**RE: WYOMING AND MONTGOMERY
SITE DEVELOPMENT PLAN FOR SUBDIVISION
PROJECT 1010550/ 15EPC-40032**

Tierra West, LLC on behalf of W&M Company respectfully requests final DRB signoff for the Site Development Plan for Subdivision. Please find the following responses addressing the conditions of approval from the Official Notification of Decision dated January 15, 2016 listed below:

Project# 1010550
15EPC-40032 Site Development Plan for Subdivision

DESIGN STANDARDS

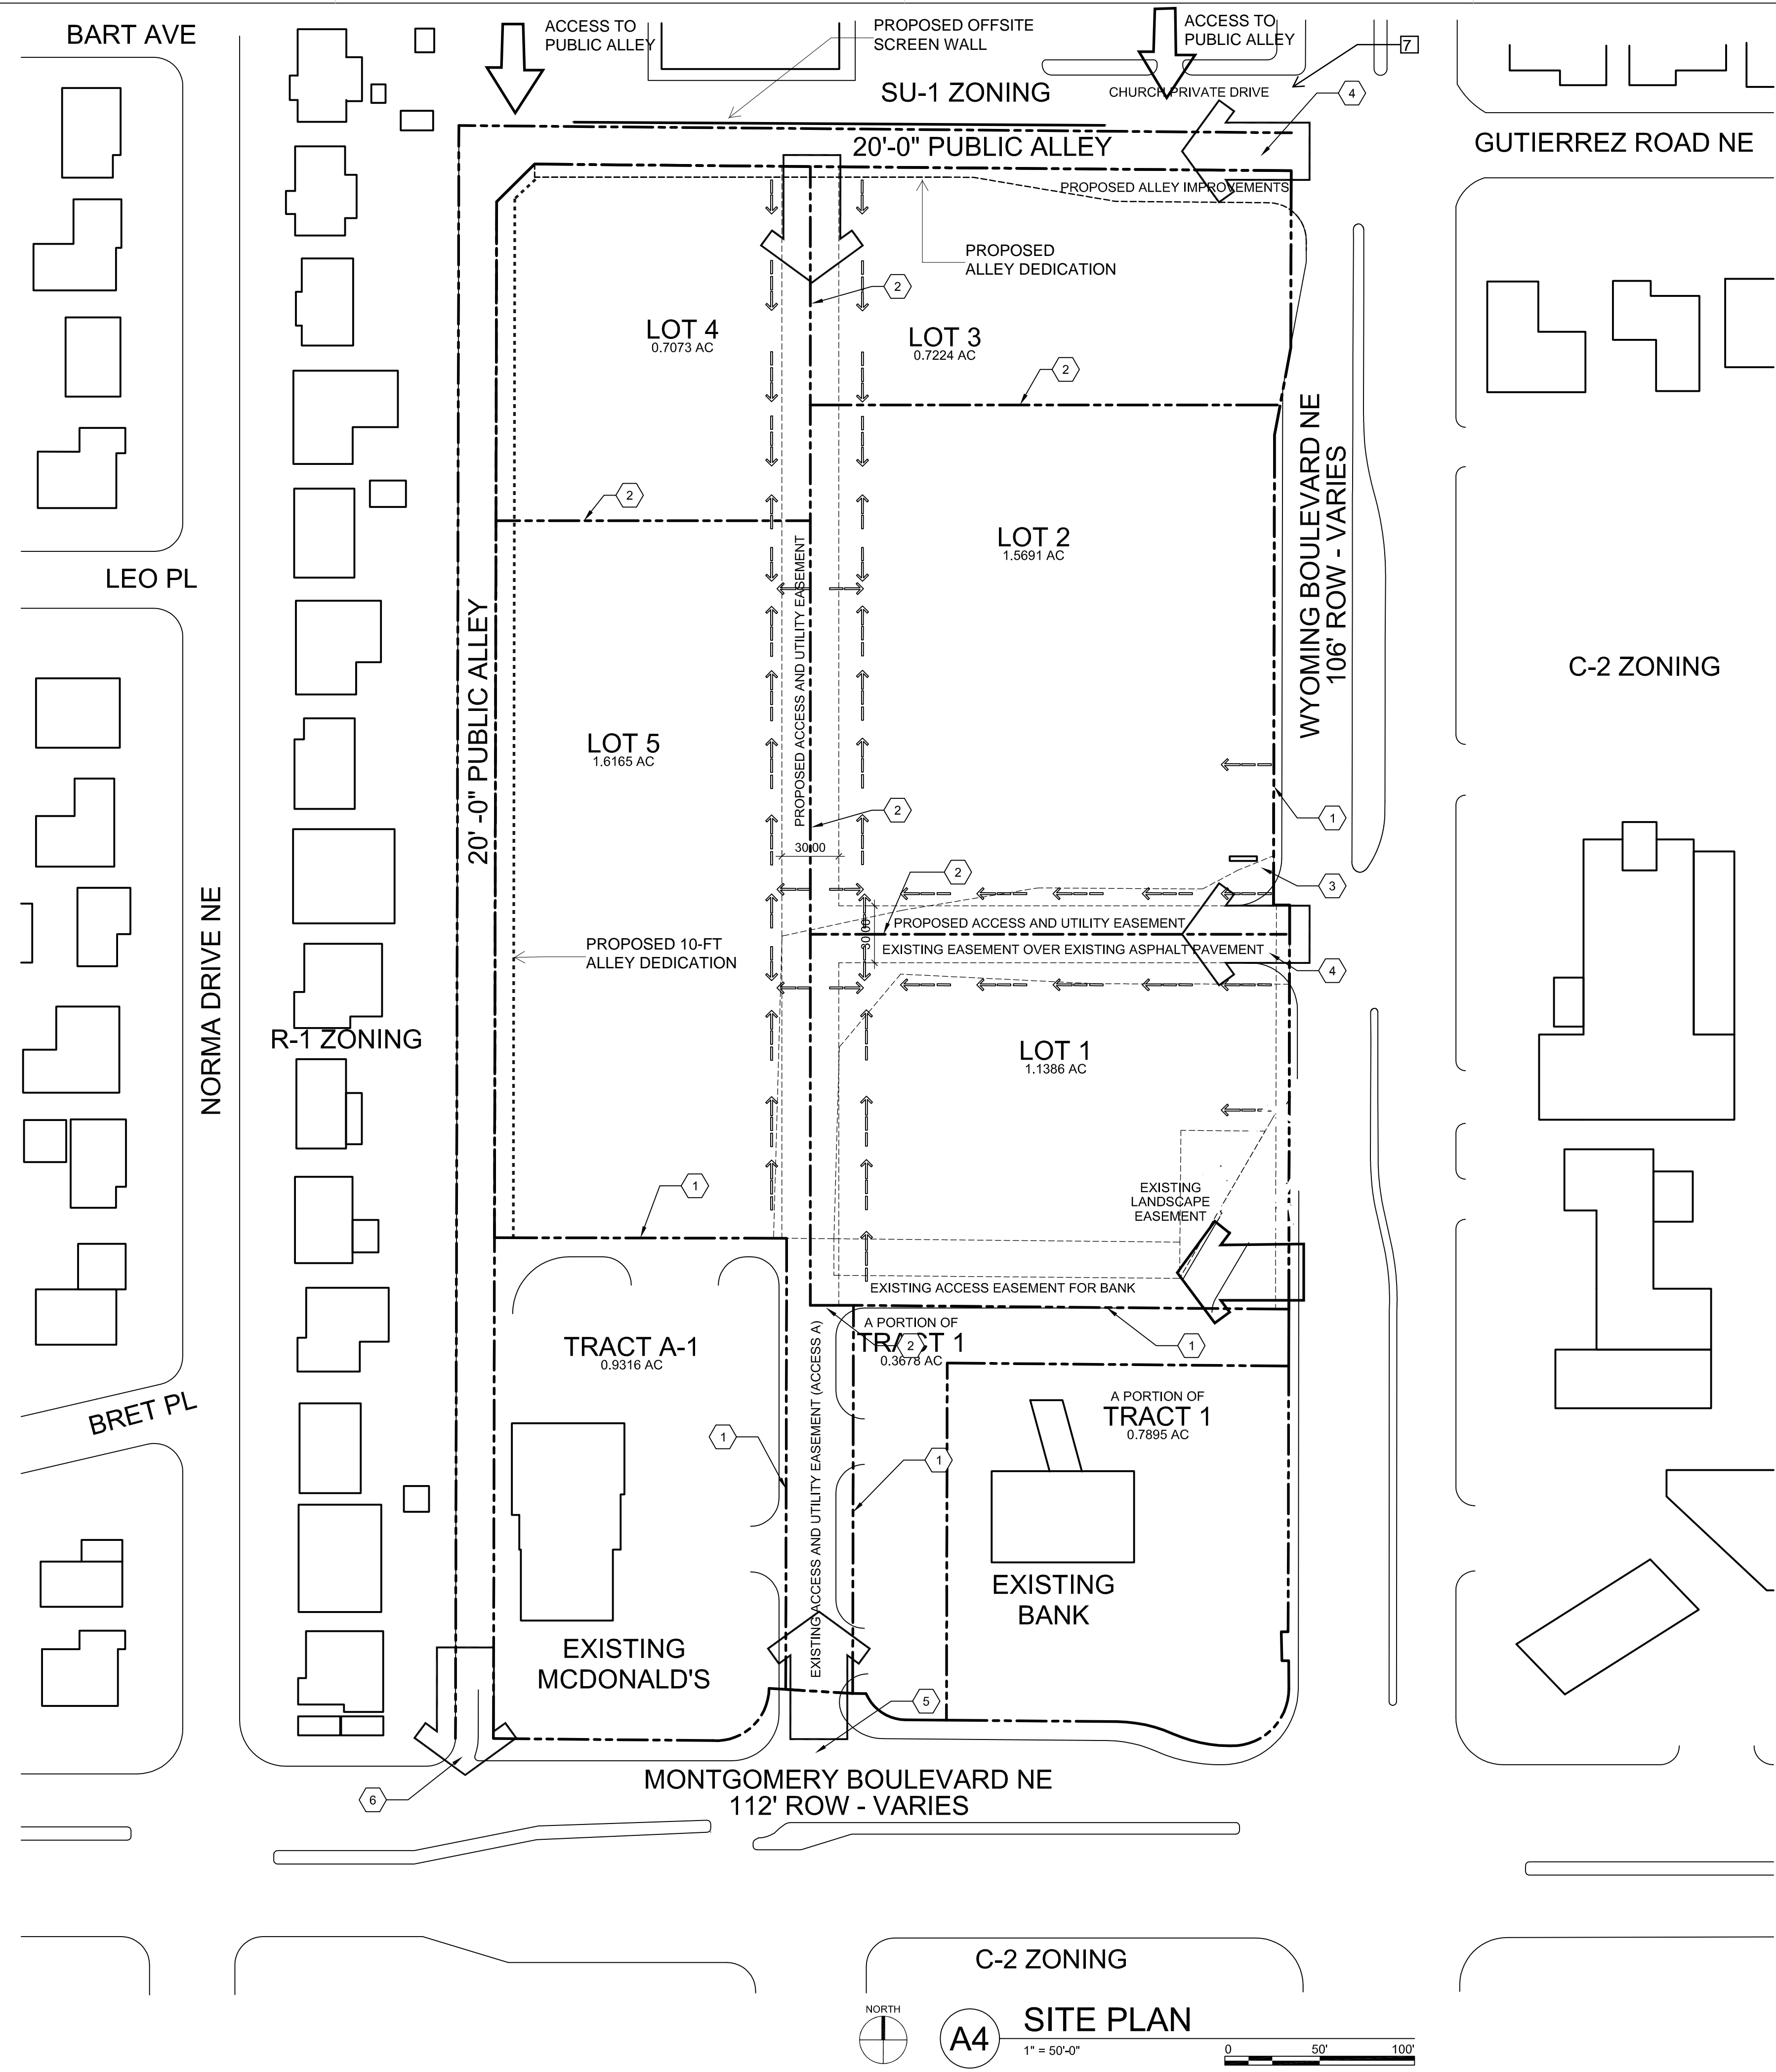
- B. Section II. - Setbacks & Building Height Limitations shall be revised to state that building heights are regulated by Section 14-16-2-15(C)(1)- Office & Institution Zone which allows a maximum building heights of 26', however, any structure over 26' must fall within 45 degree angle planes drawn from the horizontal at the mean grade along each internal boundary of the premises and each adjacent public right-of-way centerline. Additionally, structures shall not exceed 26' within 85' of a lot zoned specifically for houses.

- C. Section III. – Parking shall be revised to include a note stating that all off-street parking areas shall comply with all First Flush Drainage Ordinance requirements as well as a section outlining conformance with Designated Disabled Parking Space requirements.

- D. Section IV.(a)(ii)- Pedestrian Connections & Amenities shall be revised to reference the correct 6.75 total site acreage. It currently reads that the site contains a total of 5 acres.

- E. The title for Section VI. – Walls & Fences shall be revised to read “Walls, Fences & Screening”, provide more detail regarding specific materials to be used for trash enclosures, and item 1. Be revised to cite the specific city Drainage Ordinance Number.

- F. Section VIII.- Architecture shall be revised to include information outlining the proposed FAR for the subject site as required by the Zoning Code.

- G. Section X.(f)- Signage shall be revised to reflect the Zoning Code requirements of Section 14-16-3-2(B)(4) which states that only one free-standing sign for every 300 linear feet of frontage along an arterial is allowed.

RESPONSE: Section II. Setbacks & Building Height Limitations has been updated by adding a new paragraph II.a.i to reflect the language in the condition regarding maximum height, angle planes, etc and reference to zone code section 14-16-2-15(C)(1).

RESPONSE: Section III. A new paragraph III.e.i has been added to require compliance with the First Flush Drainage Ordinance requirements. Also, a new paragraph III.f. has been added calling out required compliance with the Designated Disable Parking Space requirements per zone code Section 14-16-3-1(F)(9)(a)-(c)

RESPONSE: Section IV.a.ii. has been updated to show the actual acreage, which is 6.75 acres.

RESPONSE: Section VI. Title has been updated to include the word Screening, and a new paragraph VI.b.ii. has been added to call out materials acceptable for trash enclosures.

REPSONSE: Section VIII. A new paragraph VIII.b has been added stating the maximum FAR of 1.0.

RESPONSE: Section X.f. This paragraph has been updated to show the exact language stated in the condition.
